memorandum

from Scott Olmsted, ESA

subject Review of 5637 Mercer Way – August 23, 2018 *Revised* Critical Areas Report

A PORTION OF GOVERNMENT LOT 3, OF SECTION 19, TOWNSHIP 24 NORTH, RANGE 5 EAST, W.M., KING COUNTY, WASHINGTON

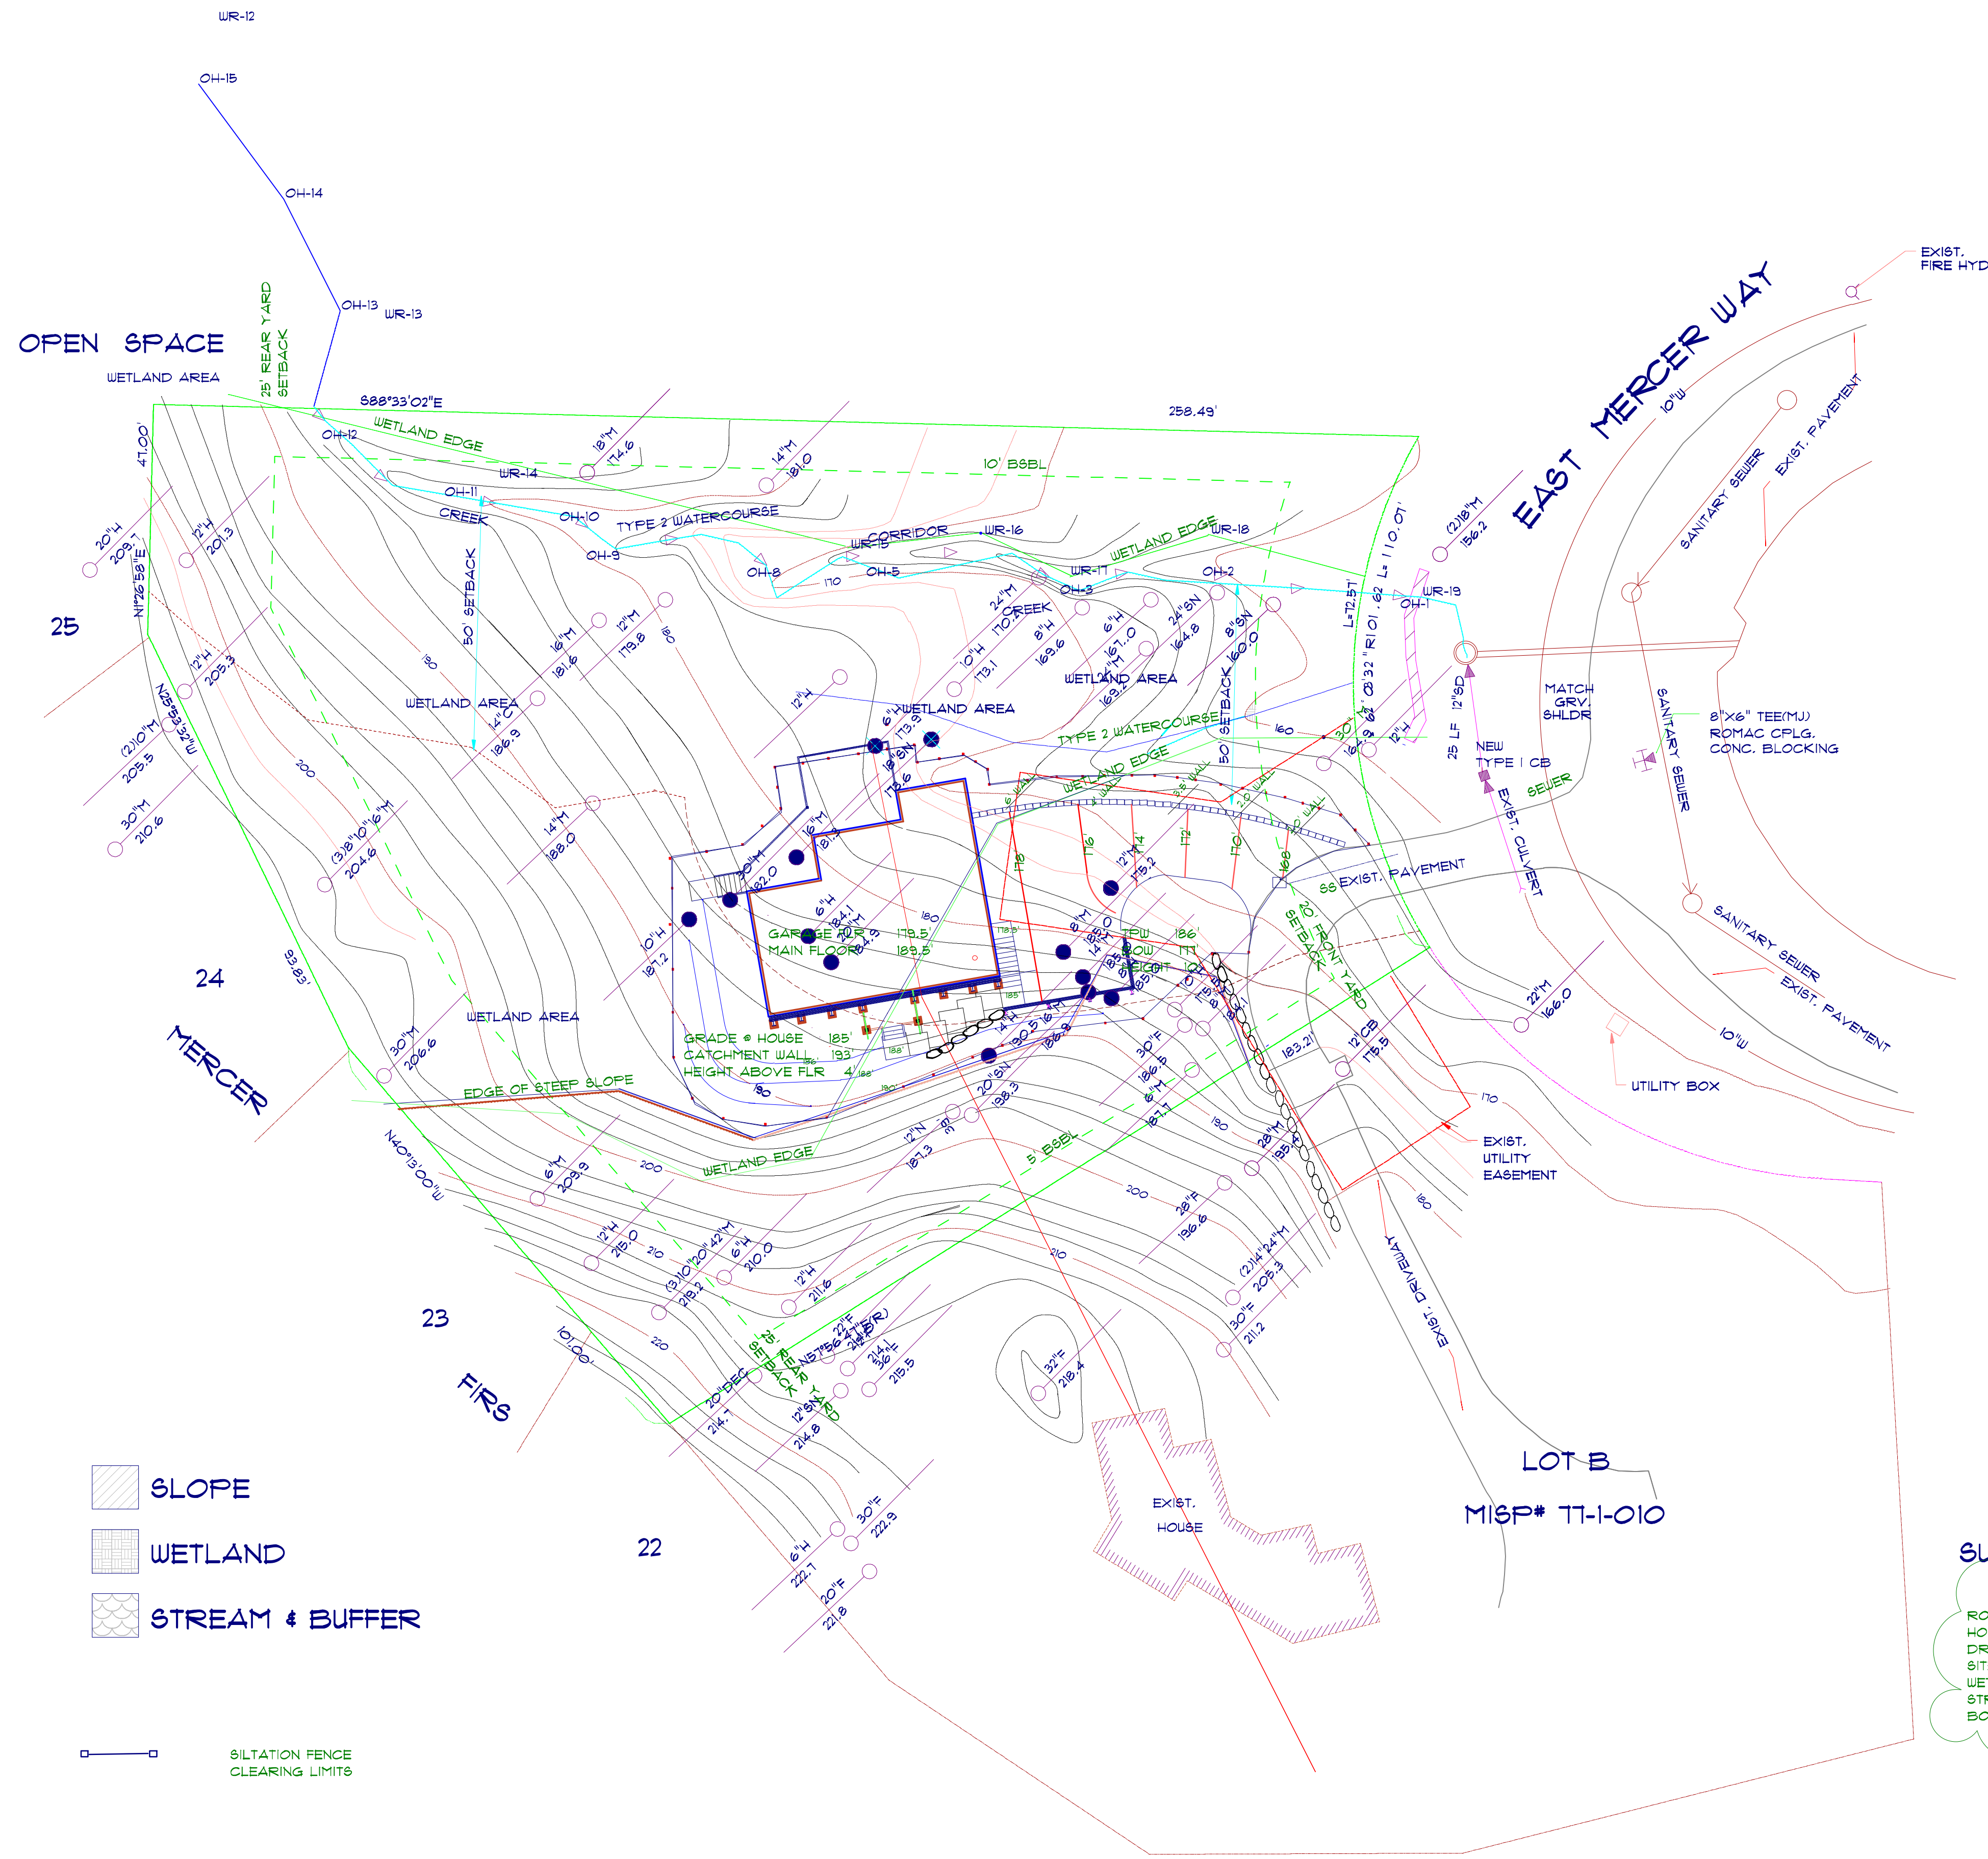
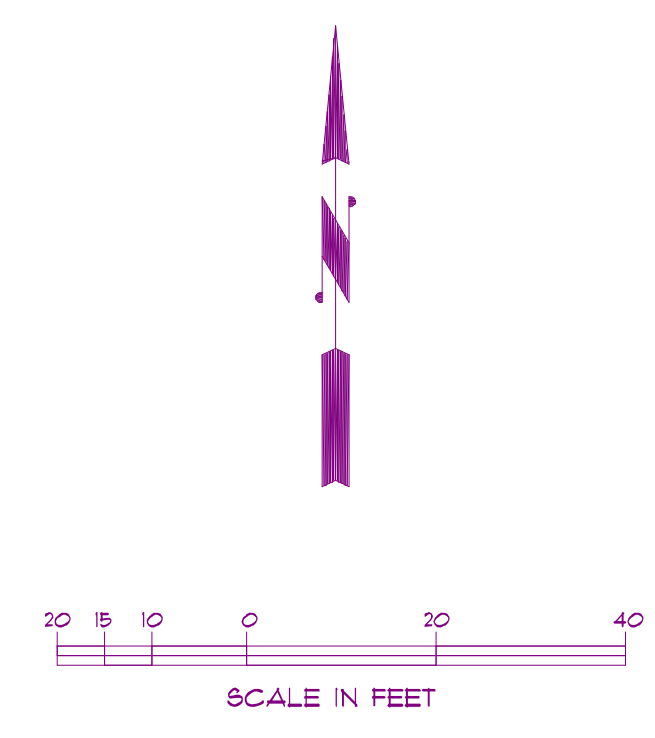
The August 2018 memo indicates temporary wetland impacts were increased to 1,711 SF compared to 907 SF as proposed in 2015. The August 2018 memo states that temporary impacts are associated with house construction and site grading. Based on the 2018 Site Plan, it appears that excavation/grading will occur along the 186-foot, 188-foot, and 190-foot elevation contours, in the vicinity of the southwest portion of the proposed building. It is unclear if this area will only be excavated or if grading will also occur. In addition, it is unclear if the wetland will be graded adjacent to the building footprint to facilitate construction. The applicant should provide detailed discussion and associated impact calculations, if applicable, of the proposed excavation and grading activities. It is ESA understanding that Corps of Engineers considers grading within wetland boundaries as regulated fill, which results in a permanent wetland impact. ESA recommends that Mercer Island consider following the same interpretation to be consistent with the federal regulatory agency and have the applicant determine the area of grading and designate it as permanent wetland impact. Temporary impacts typically entail vegetation clearing and activities of that nature, which do not significantly affect grade contours. On the design plan sheet, temporary wetland impacts are bounded by a fence or wall that is not discussed in the March 8, 2018 CAR, August 2018 memo, or called out on the design sheets; information should be added about this feature. If the area encompassed

Wetland and buffer impacts do not include what appears to be a retaining wall located on the north side of the driveway; this area should be included in the impact calculations.

10. Recalculate buffer impacts applying the 50-foot wetland buffer.
11. Include the northern retaining wall in the impact area calculation.
12. Consider installing conveyance from the proposed grading area located at the southwestern portion of the development to route water around the house and discharge and spread flow north and northwest of the

house to provide continued hydrology to the down-gradient wetland and stream. Provide discussion as to how the proposed stormwater facility affects the delivery of groundwater and surface waters to the down-gradient wetland and stream.
